Botley West Solar Farm

Schedule of Changes to the draft DCO

PINS Ref: EN010147

Document Ref: EN010147/APP/8.3 Rev 5

Scale:	1:2500	at A0
Title: Streets, Access and Rights of Way Plans		
Sheet 2 of 13

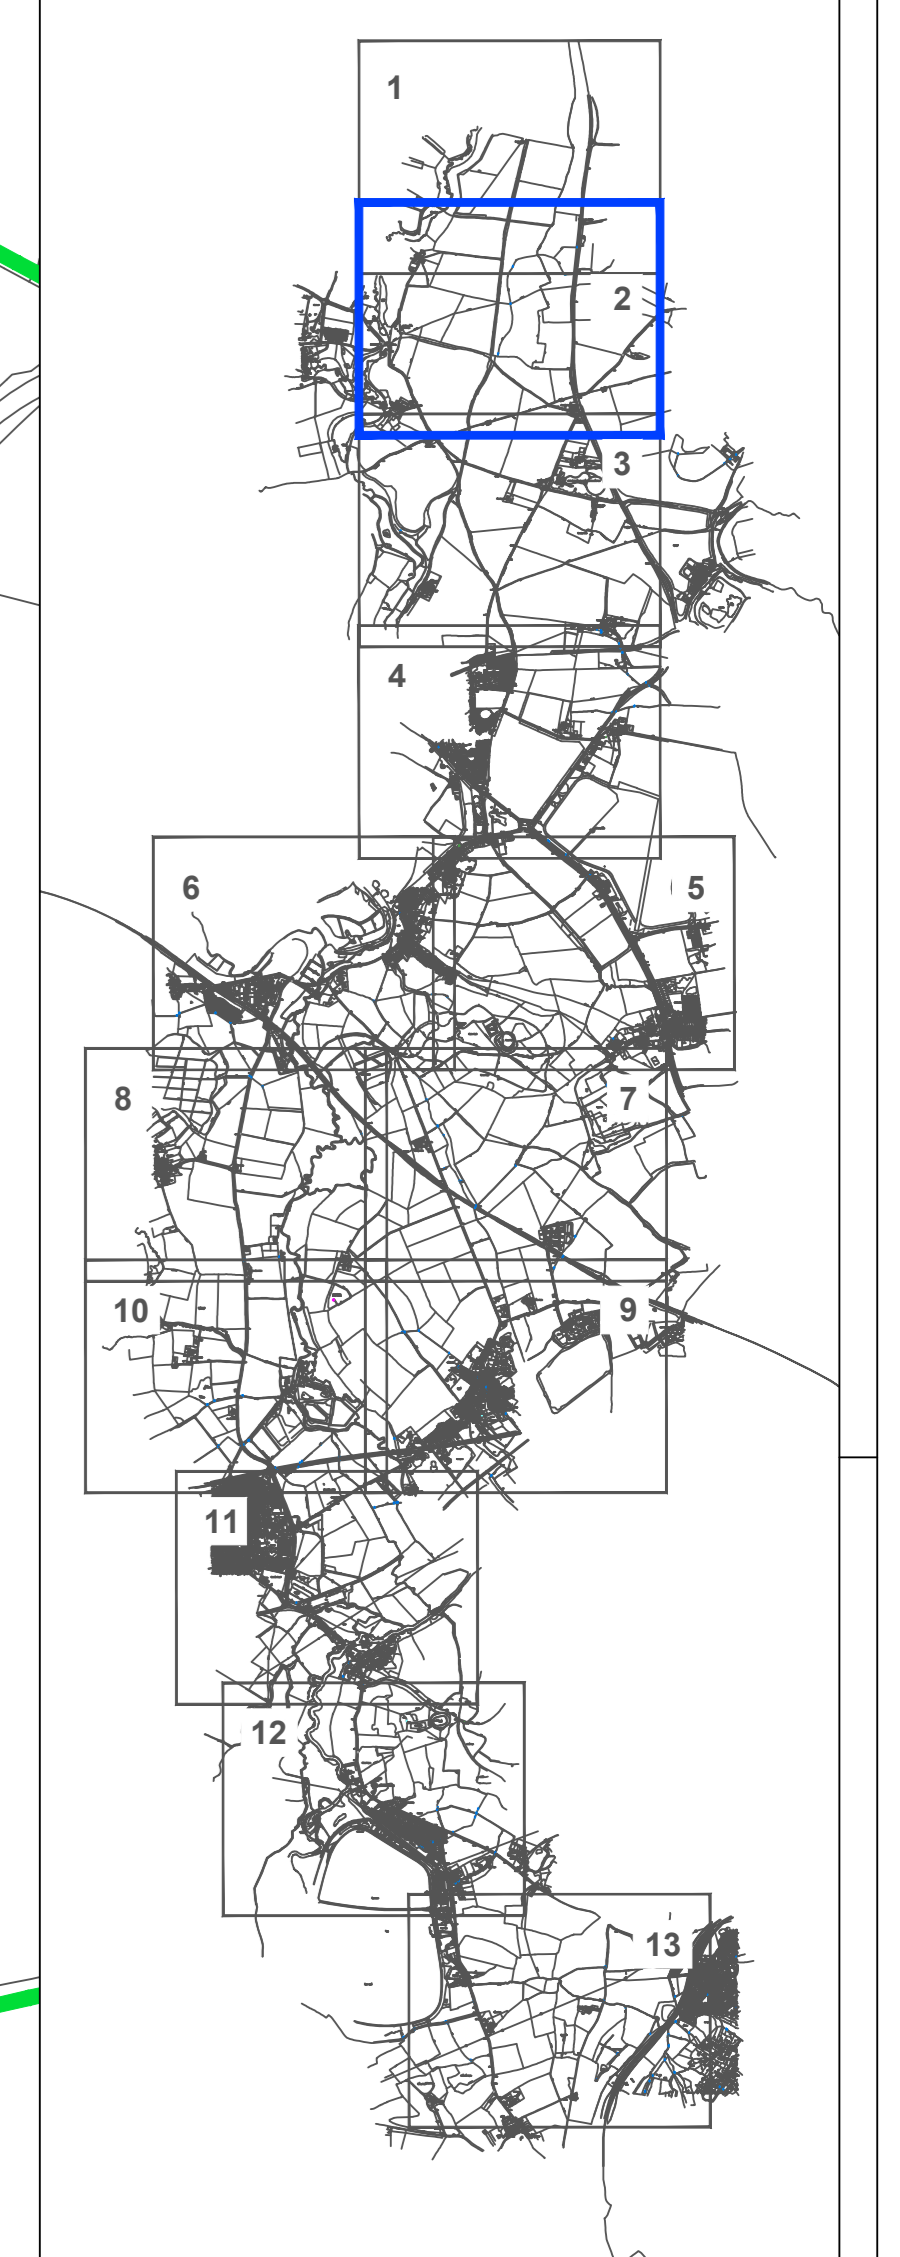
Schedule 12	Number of hedgerow and extent of removal column (2) amended in respect of the following four hedgerows:	The Applicant has updated Schedule 12 to clarify that for the four specific and limited areas of hedgerow	Deadline 2

ARTICLE / PARAGRAPH	CHANGE	REASON FOR CHANGE	DEADLINE CHANGE WAS MADE AT
	• “Removal of up to 11m of the hedgerow H2.02 within the Order limits as shown approximately within the Hedgerow removal plans Sheet 2 of 13.” • “Removal of up to 58.5m of the hedgerow H2.04 within the Order limits as shown approximately within the Hedgerow removal plans Sheet 2 of 13.” • “Removal of up to 55m of the hedgerow H3.01 within the Order limits as shown approximately within the Hedgerow removal plans Sheet 3 of 13.” • “Removal of up to 29m of the hedgerow H3.07 within the Order limits as shown approximately within the Hedgerow removal plans Sheet 3 of 13.”	identified (where the hedges extend beyond the Order limits), the drafting does not inadvertently prevent the removal of those hedgerows in full. The intention of the Applicant is for the DCO to include the power to remove the specific hedgerows identified in Schedule 12, if required. This is facilitated through Article 38(5) and is shown on the Hedgerow Removal Plans [AS-007]. The EIA has been carried out on the assumption of full removal and therefore it is justified for the DCO to facilitate that power. Notably, it is likely that most of the hedgerows identified will only be lowered for visibility splays and not removed entirely, therefore any practical limitations will be limited. The base mapping software used identifies that those four hedgerows areas are partially within the redline boundary and partially extend beyond the redline boundary. This mapping software may not be 100% reliable as
